RESPONSE TO SUBMISSIONS – MOD 10 MP08_0238
1 DENISON STREET, NORTH SYDNEY

We write on behalf of Winten Property Group (Winten) in regard to the Section 4.55(1A) modification application being MOD 10 to Project Approval MP08_0238 relating to construction of a new commercial building at 1 Denison Street, North Sydney (the site).

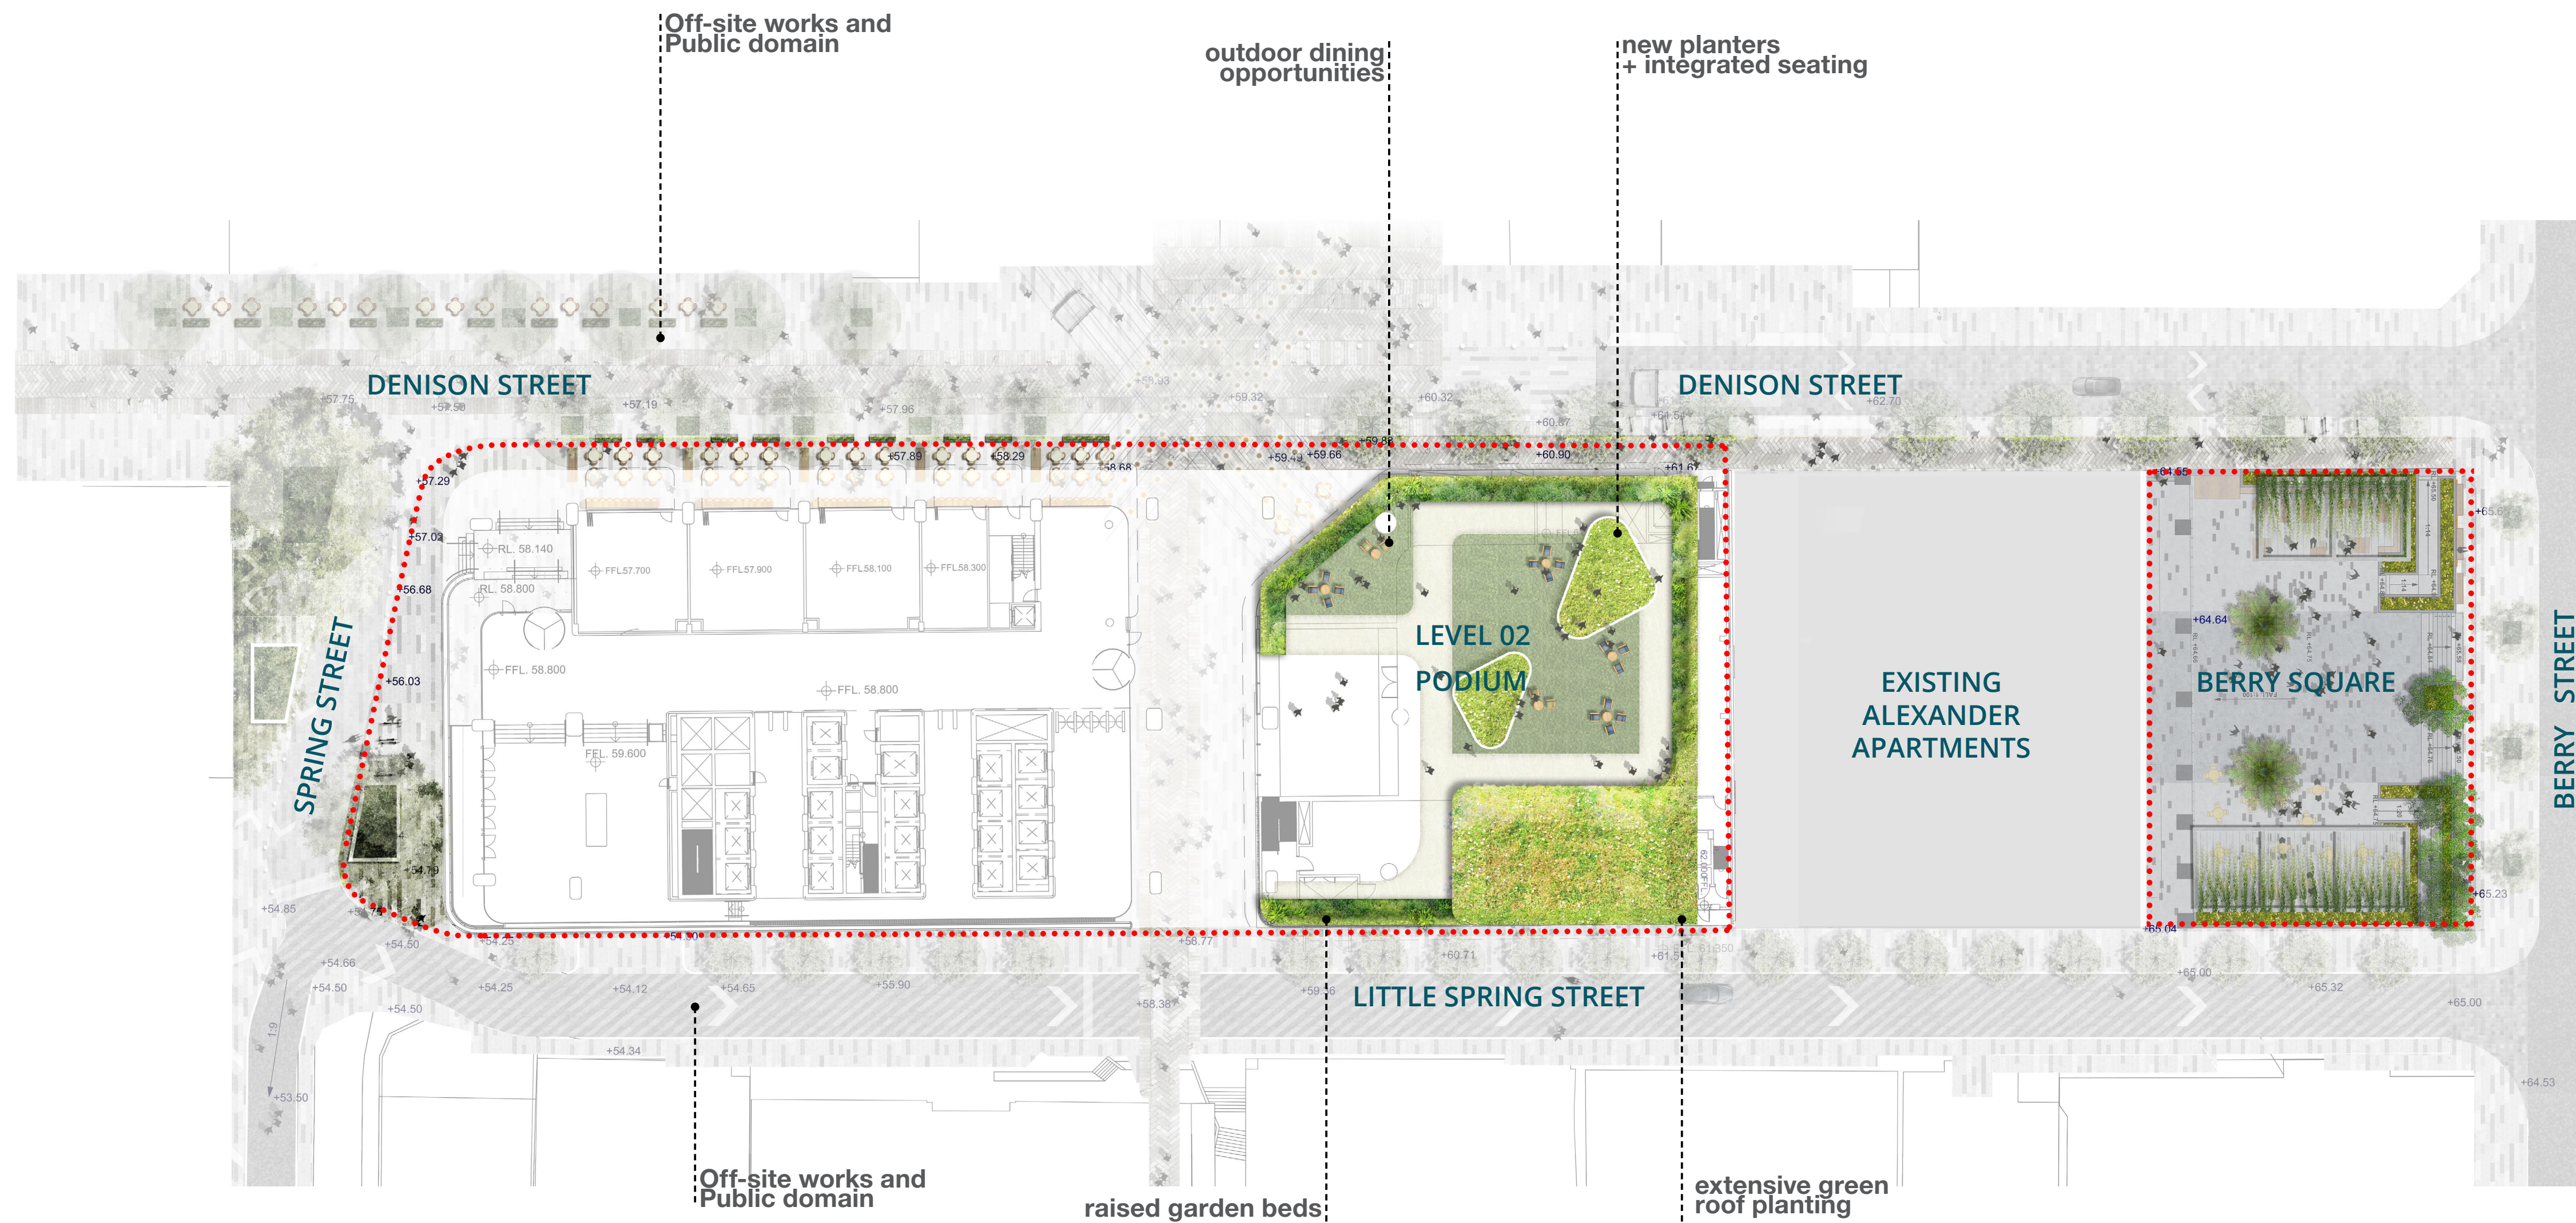
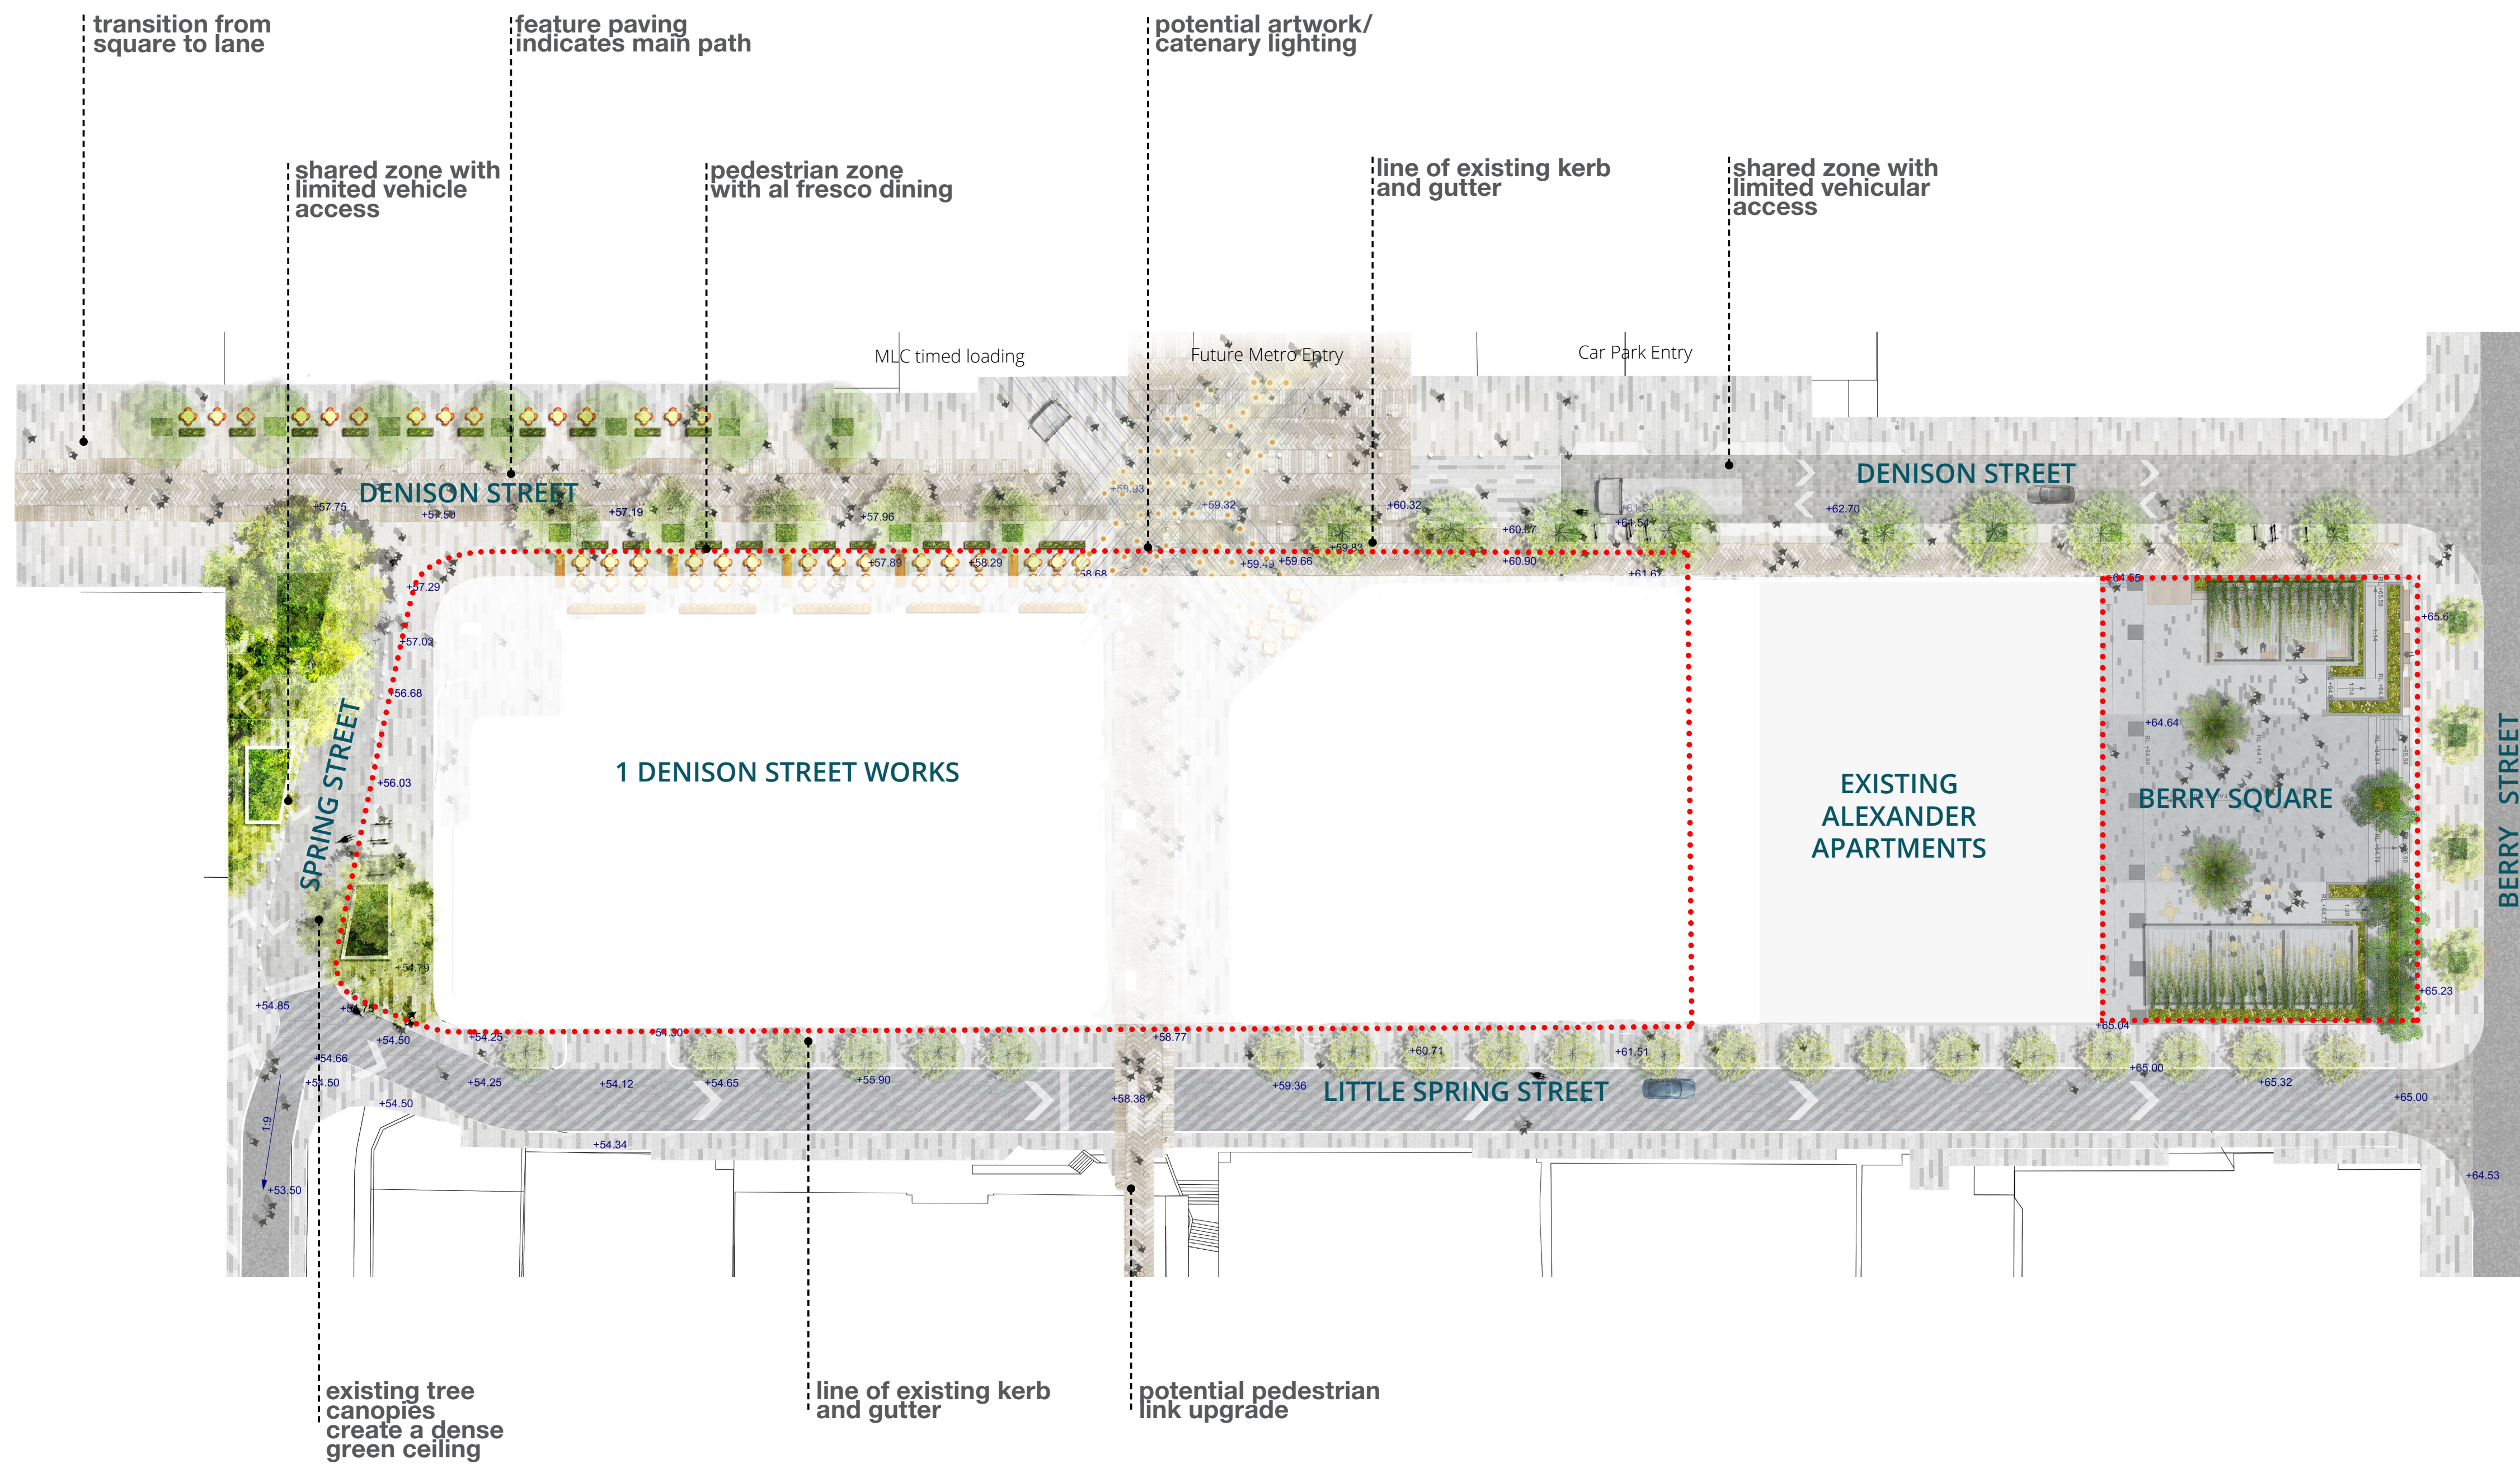
Issue	Response
Council does raised concern with the two electricity substations shown on the Landscaping Plan for Berry Square. These substations were temporary locations during construction at 1 Denison Street to provide power for the construction site and for Beau Monde after the Shopping World building was demolished. Council was advised that the substations would be removed when the substations in the new building were commissioned. This was also an issue for residents of Beau Monde. It is requested that the substations be removed off the plans so that they are not included as part of the approval or that a condition be imposed requiring the substations to be removed prior to the final Occupation Certificate for the proposal.	The Landscape Plans has been amended and submitted at Attachment A . The substations have been removed to reflect Council's concerns and the desired future outcome for Berry Square. We note that the reallocation of the substations is subject to a separate planning process requiring agreement with Ausgrid as the owner and operator of the infrastructure. This process is independent of MP08_0238 and does not form part of this application. Any future changes to the landscape and public domain plans will be prepared in consultation with, submitted to and approved by North Sydney Council prior to the relevant Construction Certificate in accordance with Condition B38 Public Domain and Landscaping.
